May 5, 2016

**Subject: 1039 Riverside Street, Second Tee Business Park Unit 2  
Final Site Plans  
Letter of Response #2**

SHEET NUMBER
 A-2
 SHEET 2 OF 2

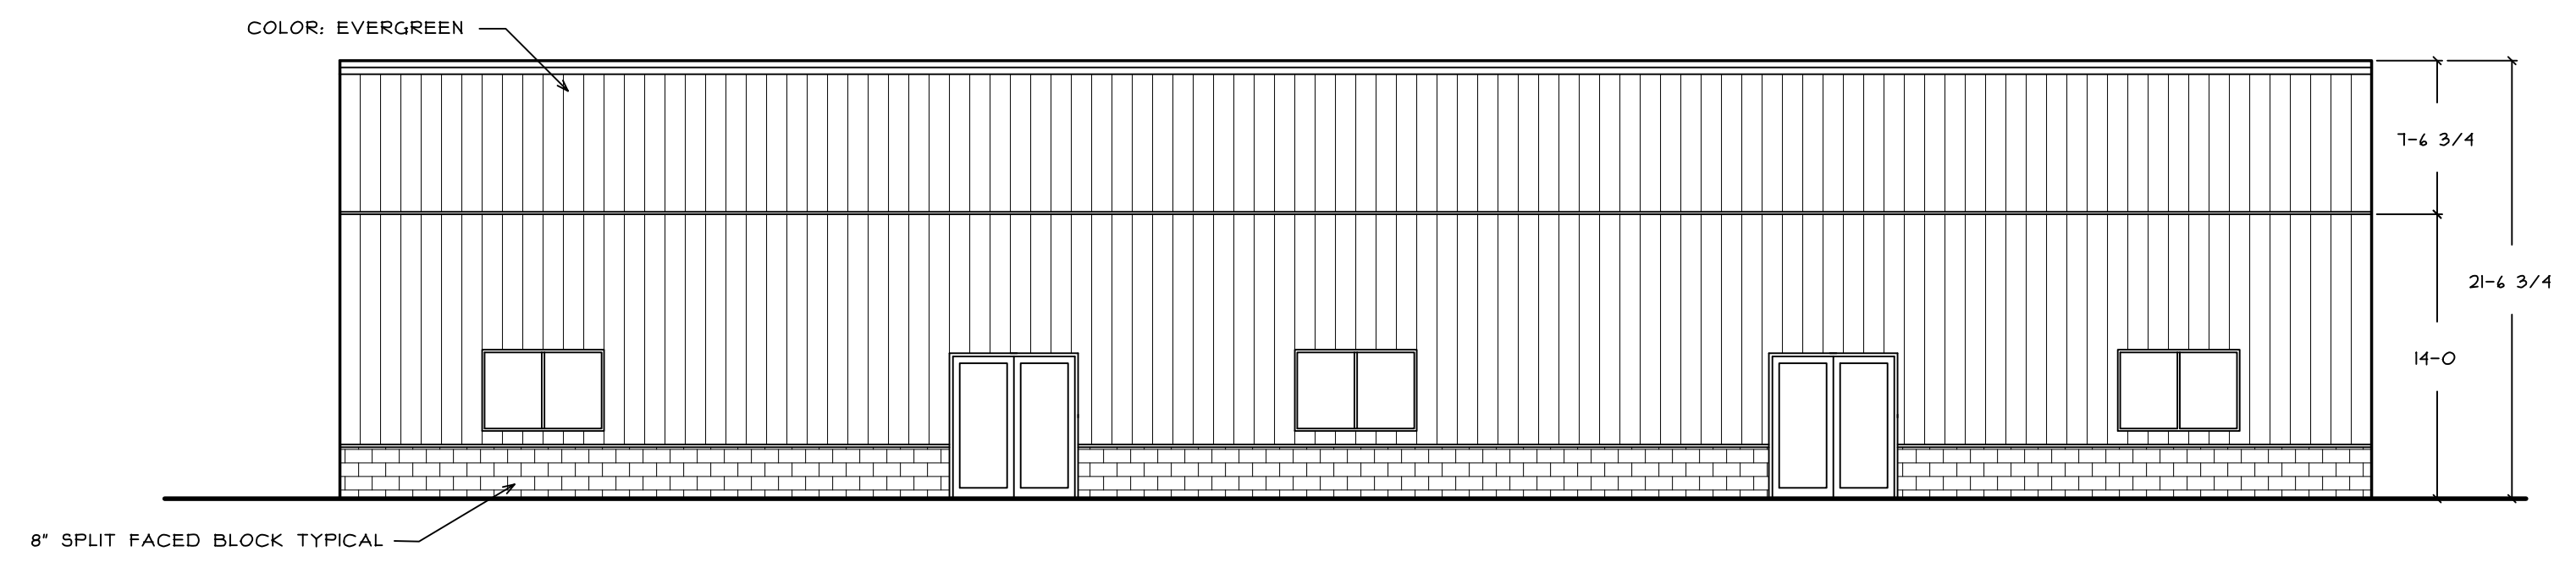
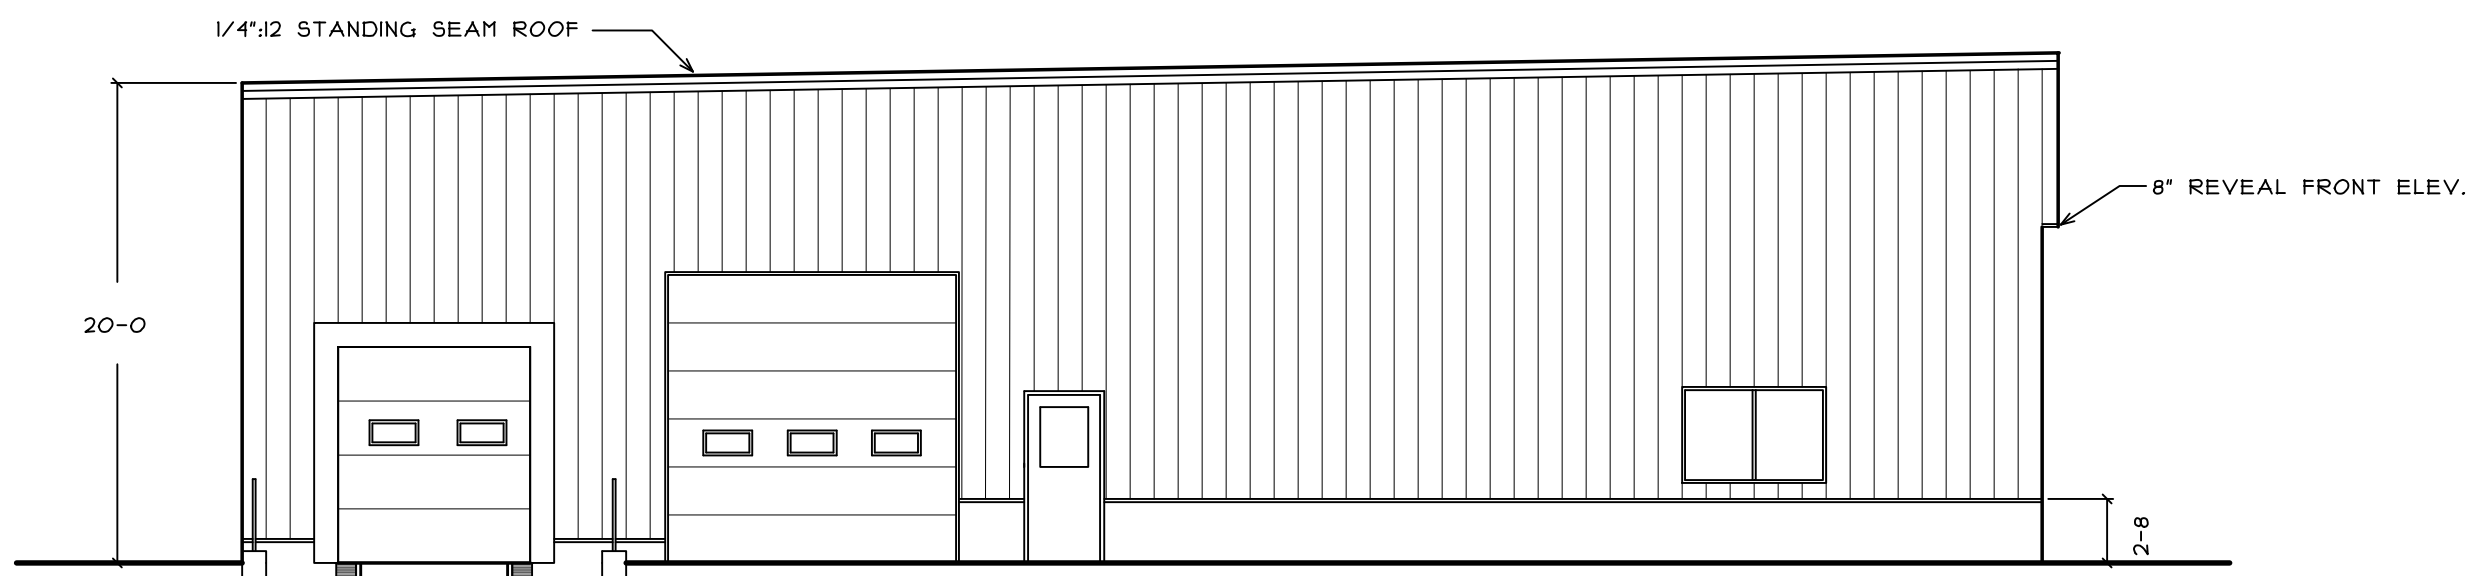
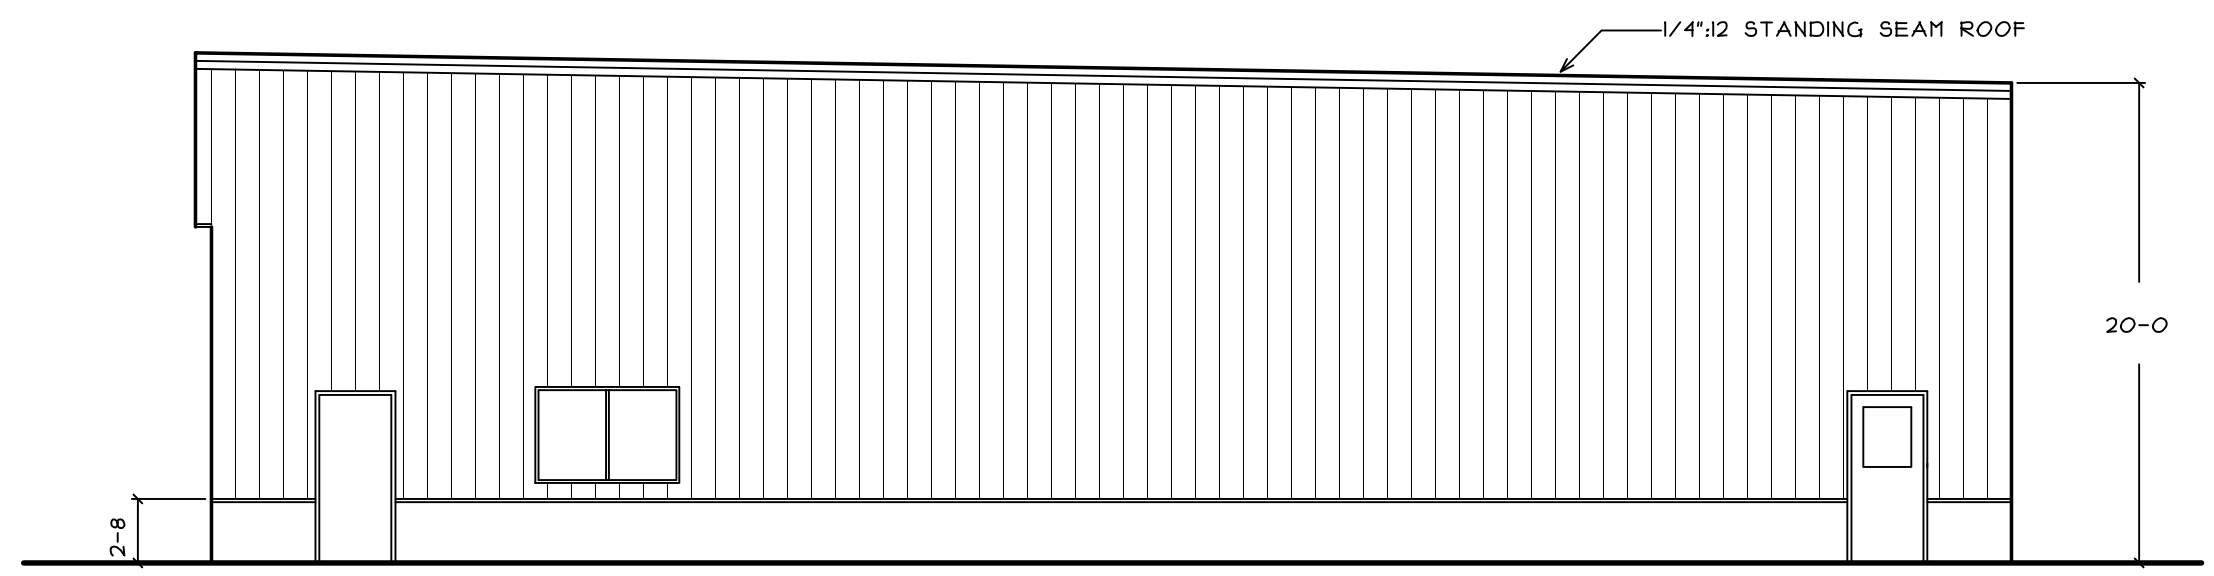
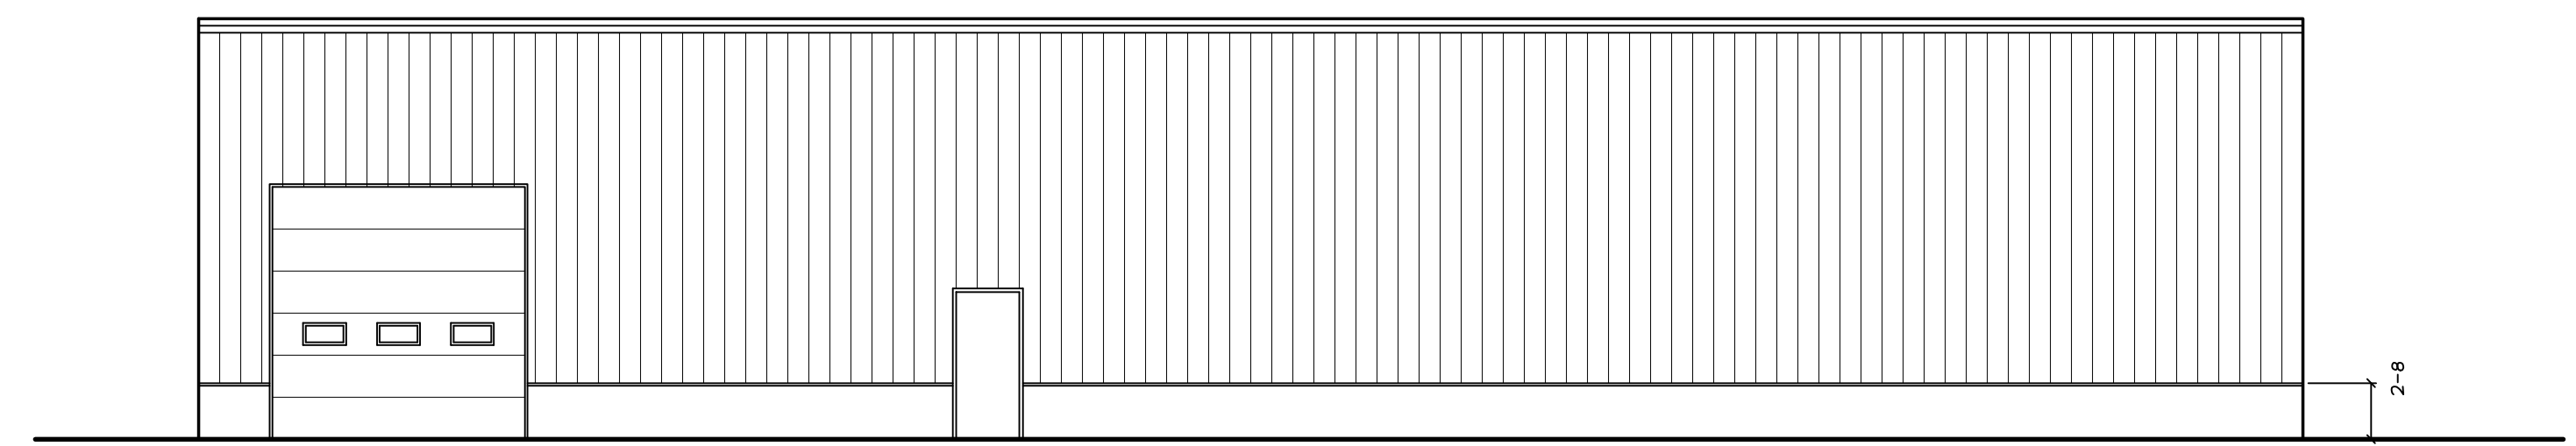
1. The loading dock at the north side of the building has been widened to 14 ft. to comply with the code requirements for dock dimensions.
2. A second, at-grade overhead bay door has been added to the north side of the building. This will require a slight expansion of the pavement surface on the end of the building. This will have no substantive impact to onsite drainage in our opinion.

3. Entry/exit doors have been added to the rear and sides of the building for code compliance reasons.
4. The front entry doors have been realigned slightly based on the interior floor planning.
